2023/0648

Demolition of existing bungalow and erection of replacement dwelling including removal of two trees

12 Tivy Dale Drive, Cawthorne, Barnsley, S75 4EN

AS PROPOSED_ ELEVATIONS + STREET SCENE CONTEXT

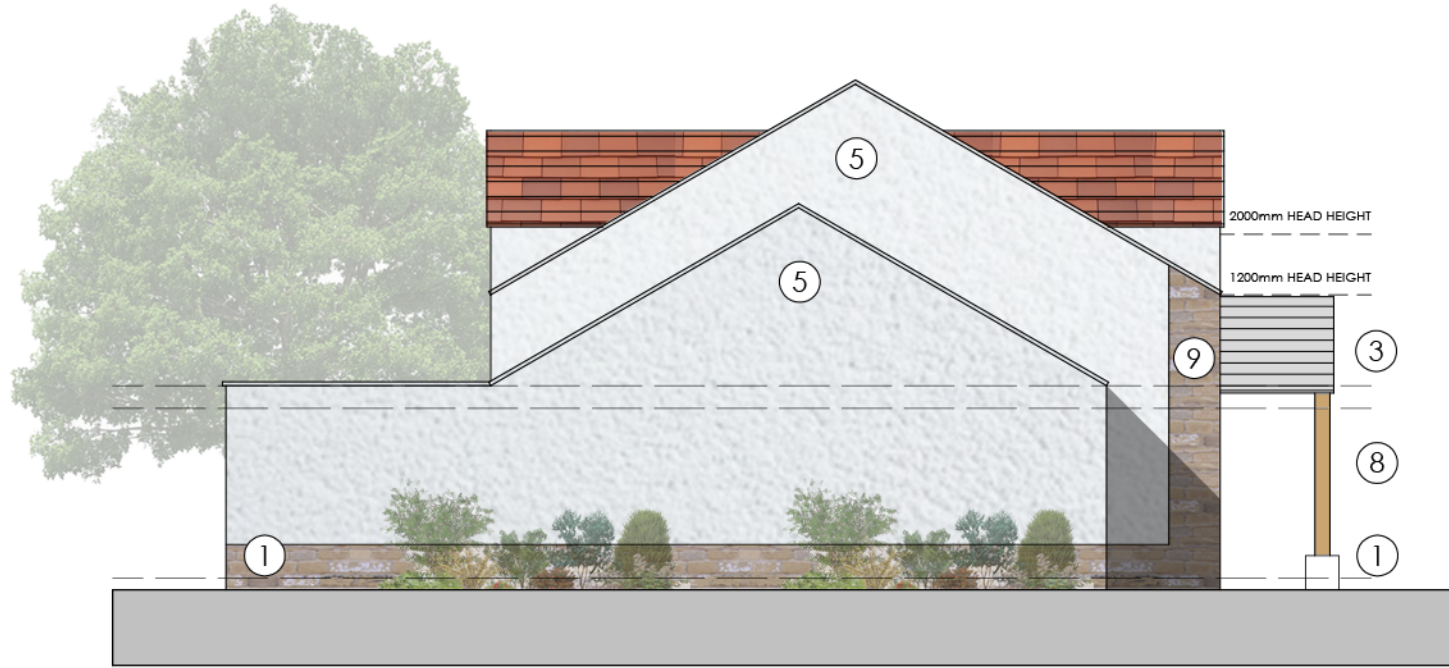
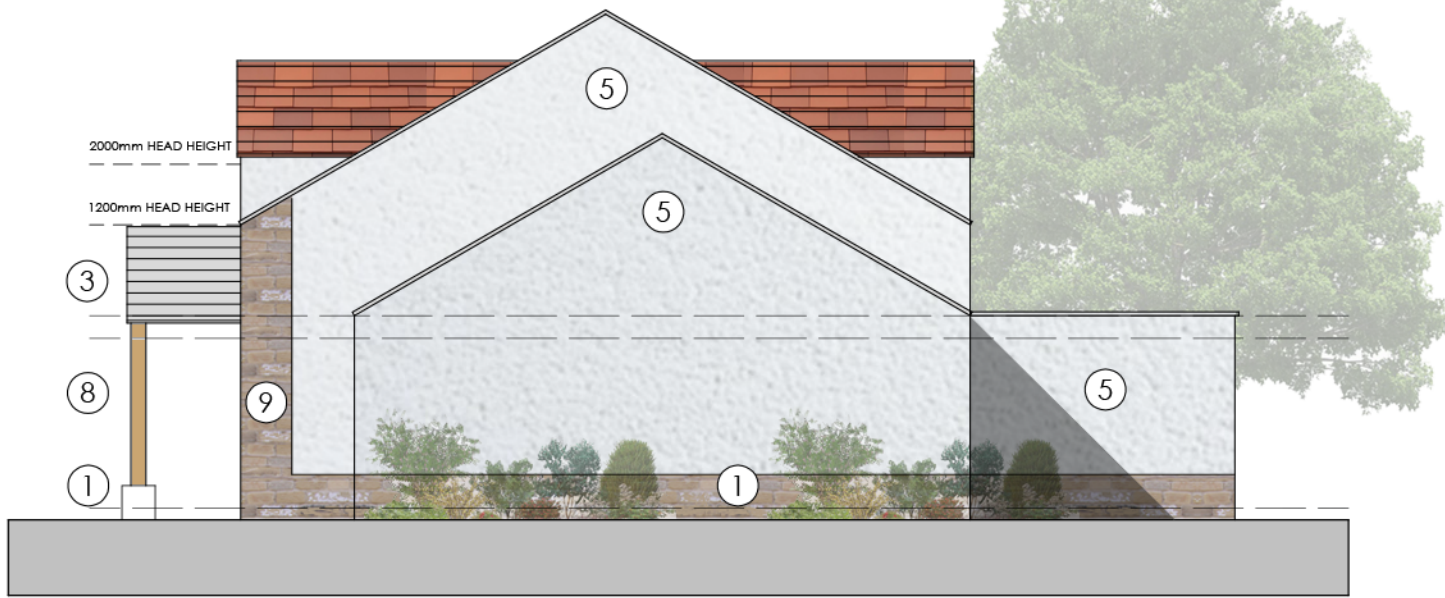
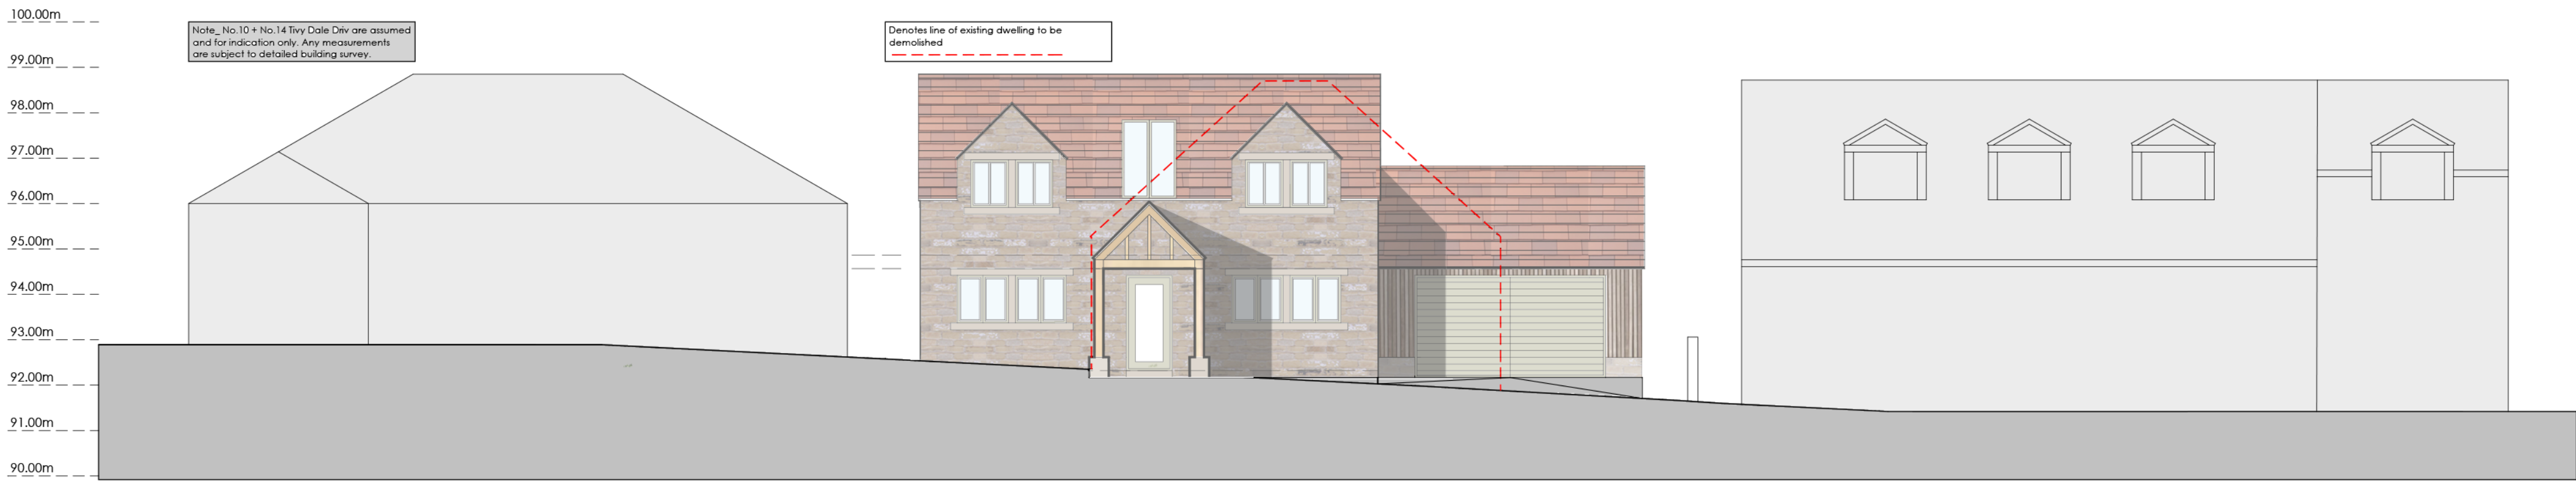
‘Cawthorne Parish Council object to the use of rendering as the material for the external walls and to the Rosemary roof tiles

Rendering is not local to the area, there are very few properties that are rendered. Whilst the house opposite has rendering, it has a significant amount of timber cladding. In the parish Council’s opinion, the rendering on this proposed property will have a startling effect on the street scene.

Section 1.5 Appearance state that “Timber cladding will be introduced around the garage which will help to break the mass of one material contemporary addition. A brick plinth will also be introduced as a nod to the existing and utilising a strong base to the ground.” Despite the timber cladding, the rendering is still very dominant. The brick plinth with a nod to the existing is hardly visible so is hardly a nod at all.

The Parish Council also object to the use of Rosemary roof tiles. The surrounding properties are slate or grey coloured roof tiles and this property should be of similar colour to blend in the street scene.

The Parish Council would like the external walls material to be changed to brick or stone. If rendering is to be used, then less than 50% of the wall to be rendered.

The roof tiles to be similar colour to the surrounding properties.

The scheme has been amended during the course of the application, in consultation with the Conservation Officer. The materials have been altered with the front of the property being faced with natural stone and a timber framed porch. The sides and rear are to be white rendered set on a stone plinth and the garage would be timber clad to the front elevation.

In terms of the proposed materials, the scheme has been amended during the course of the application, in consultation with the Conservation Officer. The materials have been altered with the front of the property being faced with natural stone and a timber framed porch. The sides and rear are to be white rendered set on a stone plinth and the garage would be timber clad to the front elevation. The proposed materials are now acceptable and will fit in well with the adjacent properties. The render to the sides and rear will not be overly visible from within the street scene, nevertheless there are other rendered properties within Cawthorne, therefore this is already a feature within the village. Concerns have been raised by the Parish Council in terms of the use of Rosemary Roof tiles, however the existing property does in fact have the same roof tiles, albeit they have weathered over time. The Conservation Officer also 'supports Rosemary's over a plain grey tile as these are far higher quality and will look much nicer in this location.'
